Engineers Comments Regarding Surface Water Drainage

Application No: AL/36/20/DOC

Site Address: The Studio Tudor Drive Westergate Aldingbourne PO20 3YT

Description of Works: Approval of details reserved by condition imposed under ref AL/34/17/HH relating to Condition Nos 3 - materials & finishes and 4 - surface water drainage.

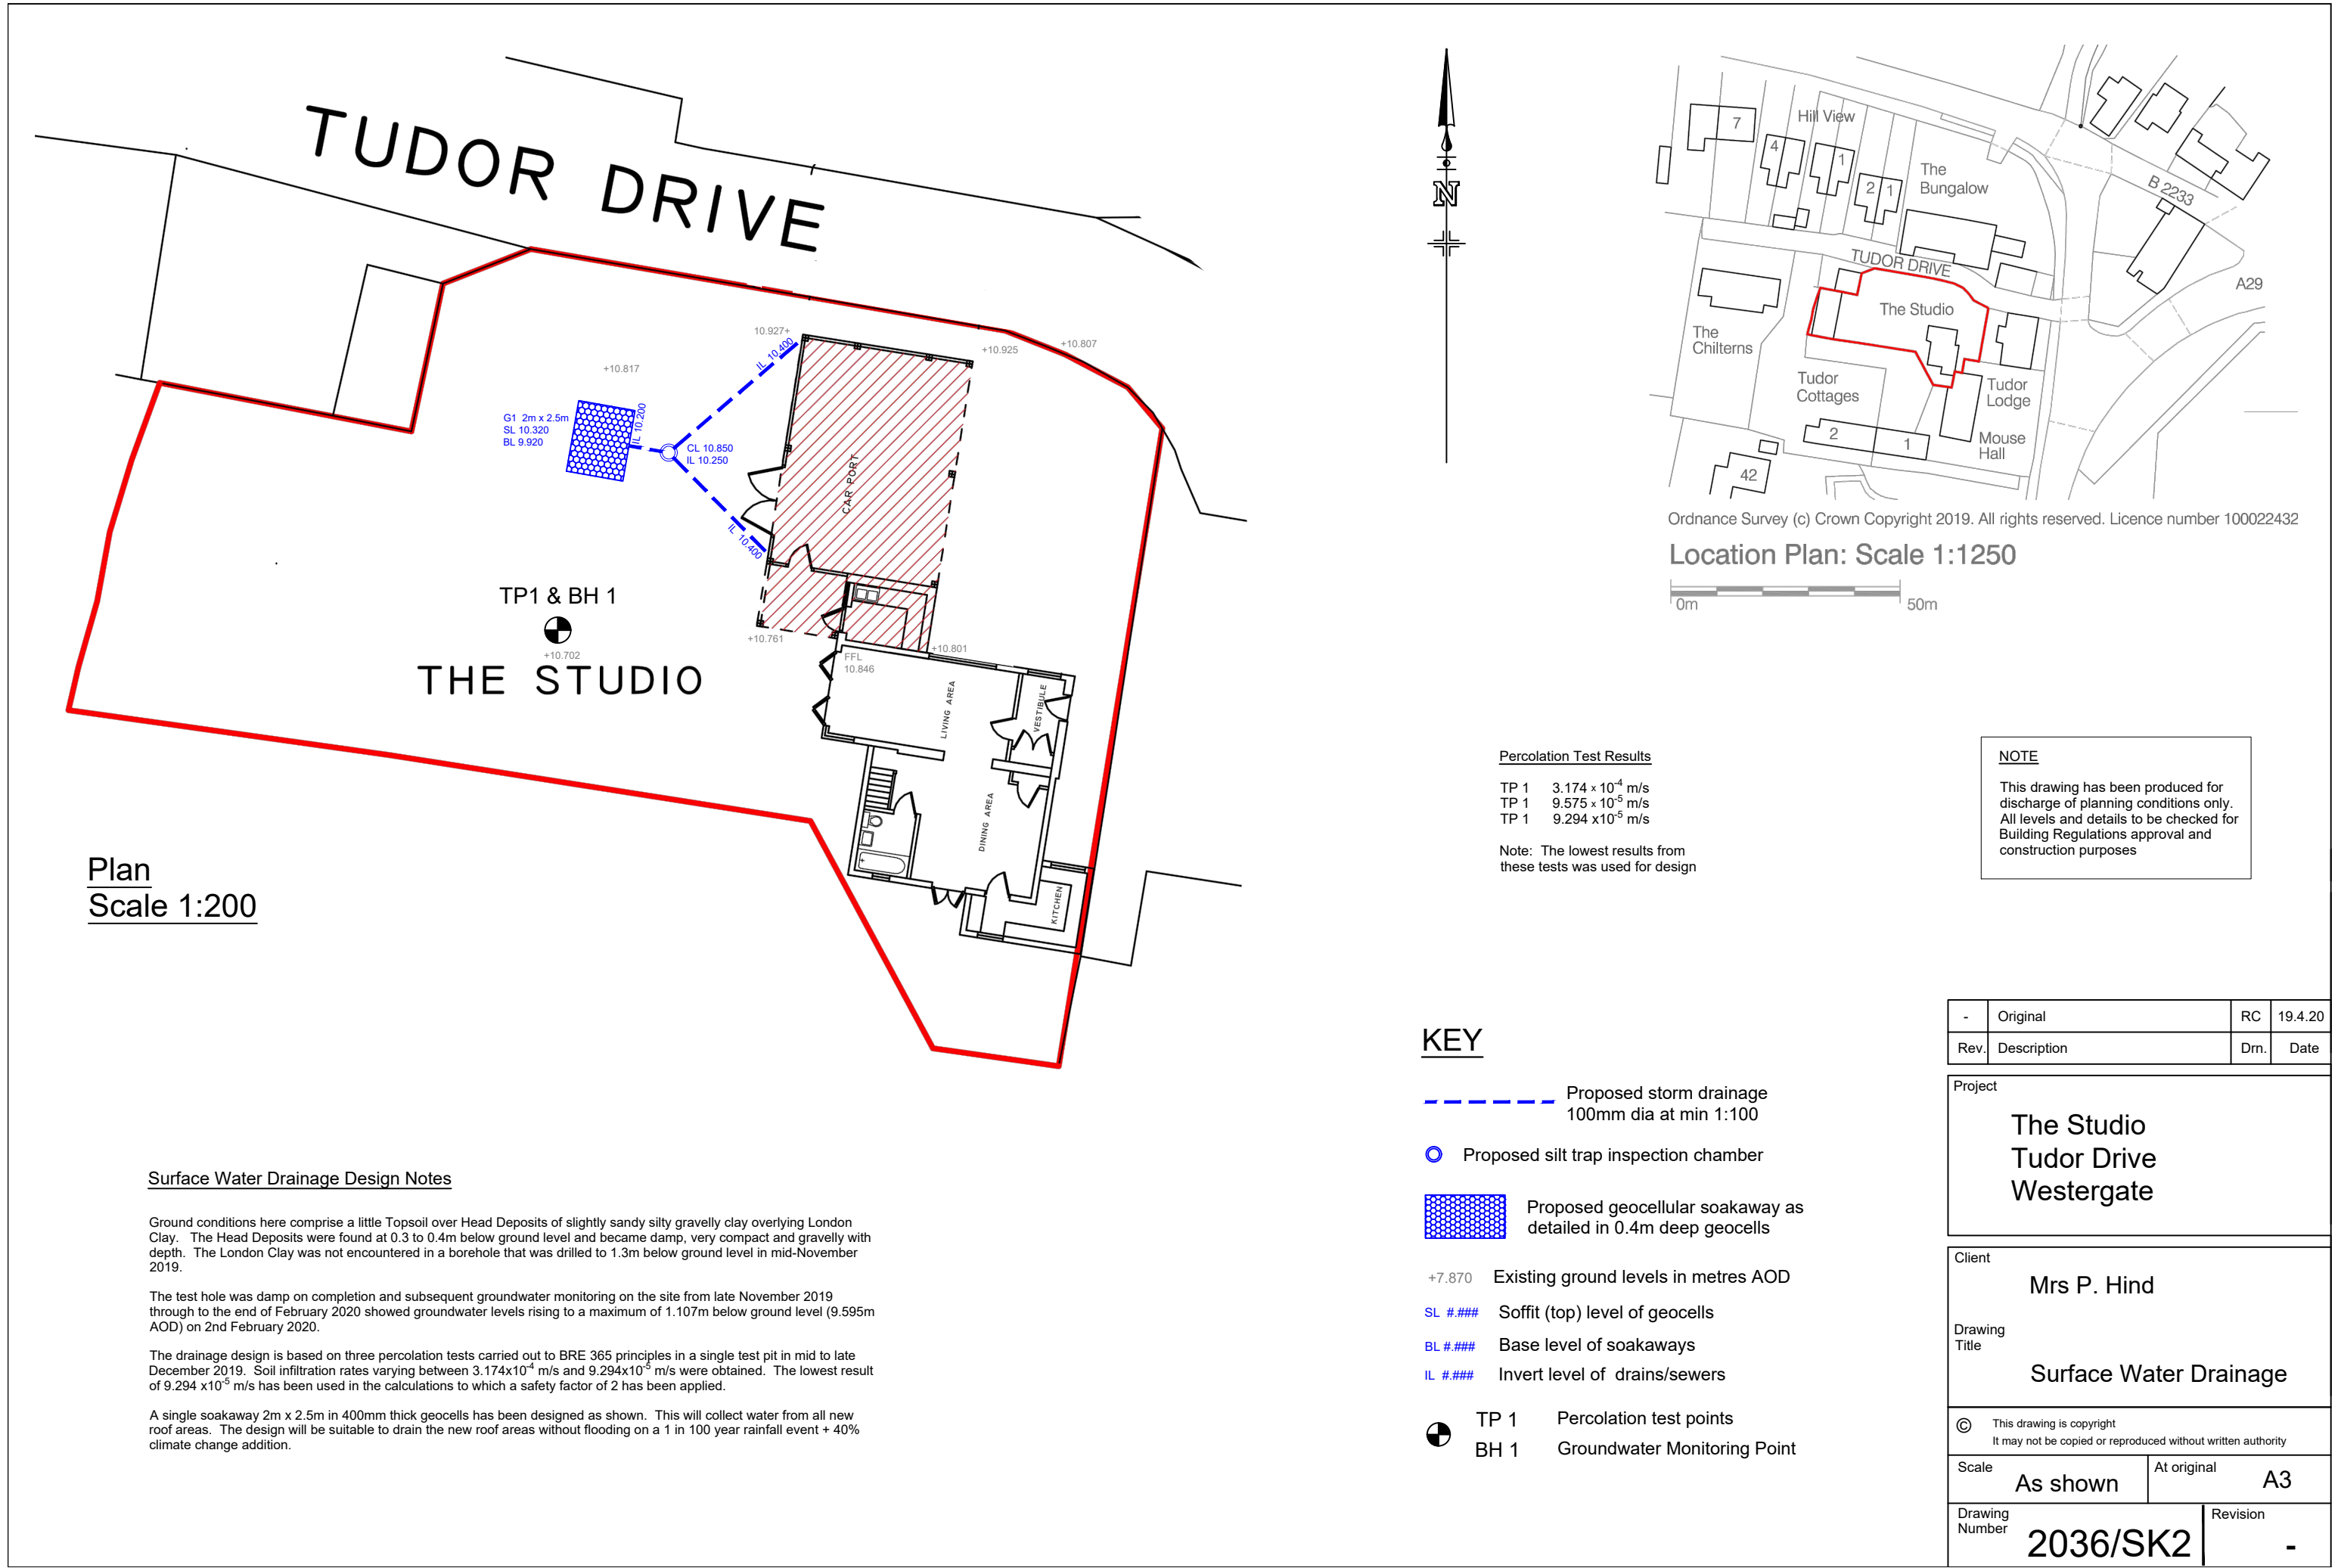
1. Please provide a construction detail for a concrete pipe bed and surround for where pipe depths are less than 900mm. Plus amend note as to when each surround should be used (Granular where cover to crown is greater than 1200mm in vehicular areas, or greater than 900mm elsewhere. For shallower depths concrete surround.)
2. Please confirm the dimensions of the trial pits within the Surface Water Drainage Notes.
